Consultation Response from Alan Smith,
KC Waste Strategy(Refuse & Recycling)

2025/91185 building at, Back Chapel Lane, Moldgreen, Huddersfield, HD5 9BG

Demolition of redundant engineering building and erection of student accommodation block

Responding Ref: WPS 25-017

**1** PROP. SITE PLAN  
 1 : 200

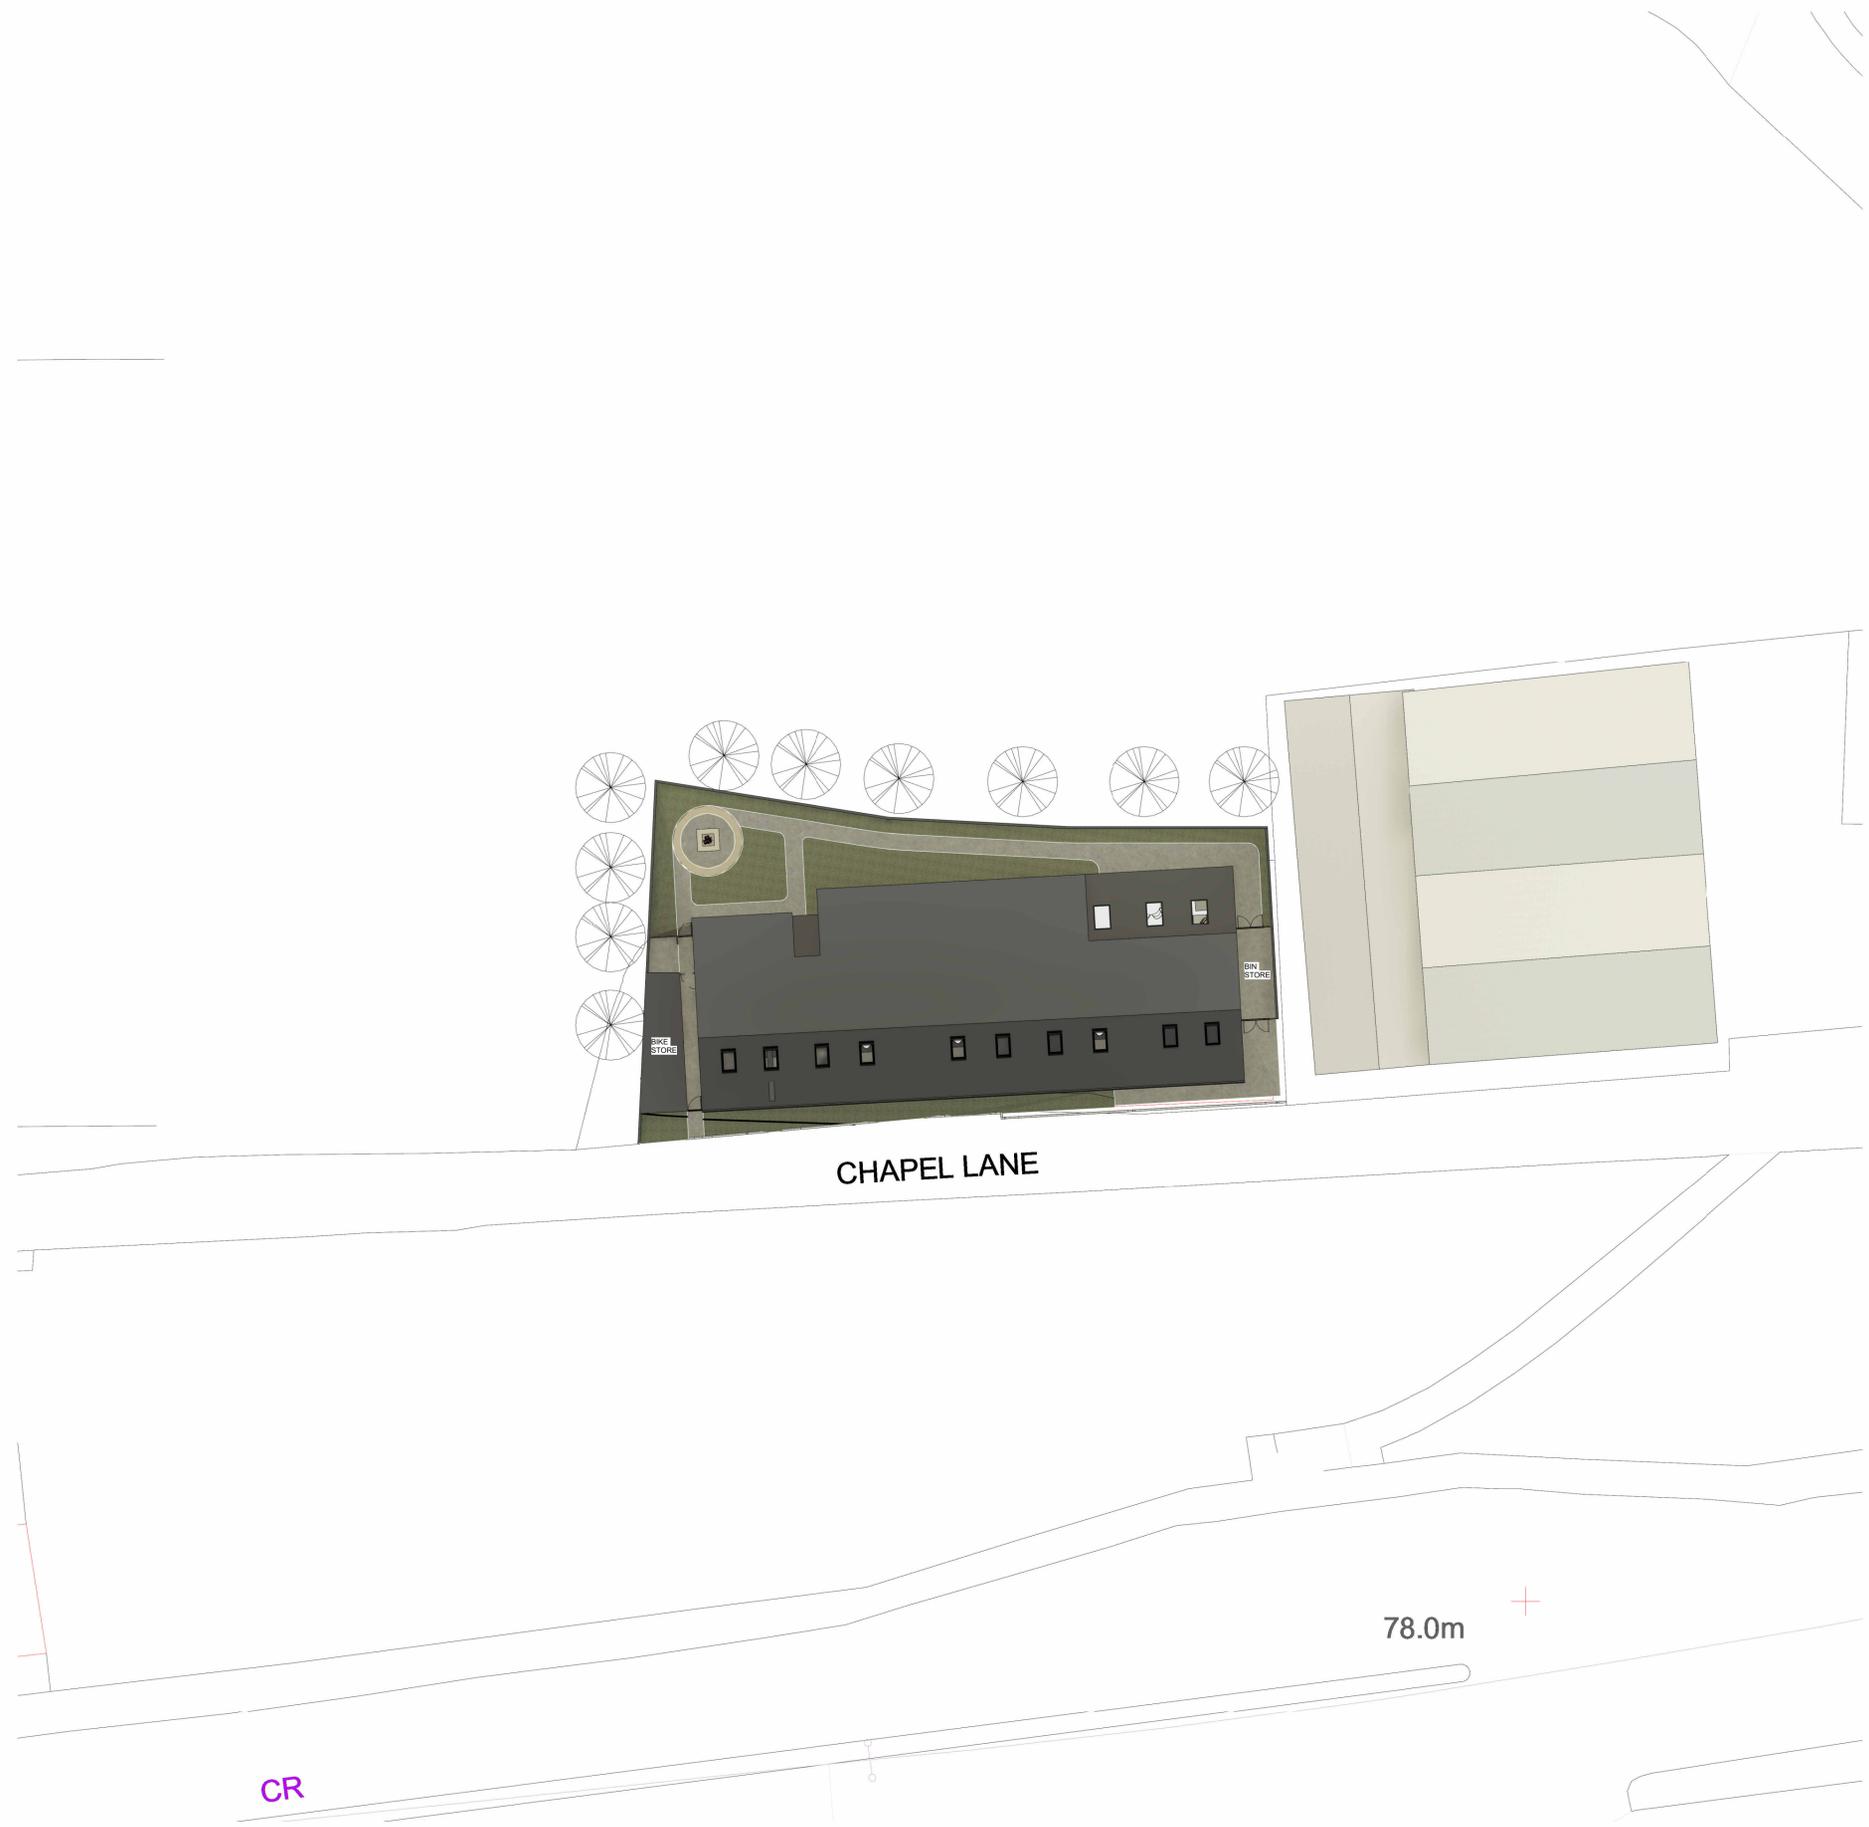
- The application is for the construction of 31 apartments. The plan shows the proposed wheeled bin store located at the East Side of the building off Chapel Lane. Waste storage capacity for 31 apartments should consist of 180ltr x 31 = 5,580ltrs. Assuming the use of 1,100ltr wheeled bins this equates to 5 containers each for both residual waste and recycling. So, **10 x 1,100ltr wheeled bins would be needed.**

- The communal waste storage area should be secured to prevent unauthorised use, rough sleeping, damage or theft.
- The bin store should be of suitable dimensions to accommodate the bins and constructed in compliance with the details specified in the design guide.

- Access from the bin store area to the Bin Collection Point (BCP) on Chapel Lane next to the highway should be constructed to withstand point loading and movement, impacts of larger bins over time, and to resist future rutting, pitting, cracking or other such surface degradation that would impair bin manoeuvring. **A drop kerb should be installed if there is a change of levels from the BCP to the highway.** Wheeled bins must not be permanently stored on the pavement or highway on Chapel Lane. There should be room to accommodate 5 x 1,100ltr at the BCP.

- A) Before development commences, further details to ensure suitable storage, and access for collection of wastes from the dwellings shall be submitted to and approved in writing by the Local Planning Authority. The approved details shall be provided before first occupation and shall be so retained thereafter.
- B) Before development commences, details of the management and maintenance of refuse storage areas and presentation of bins to the BCP on collection day, by a designated private management company shall be submitted to and approved by the Local Planning Authority. The approved details shall be provided before first occupation and shall be so retained thereafter.
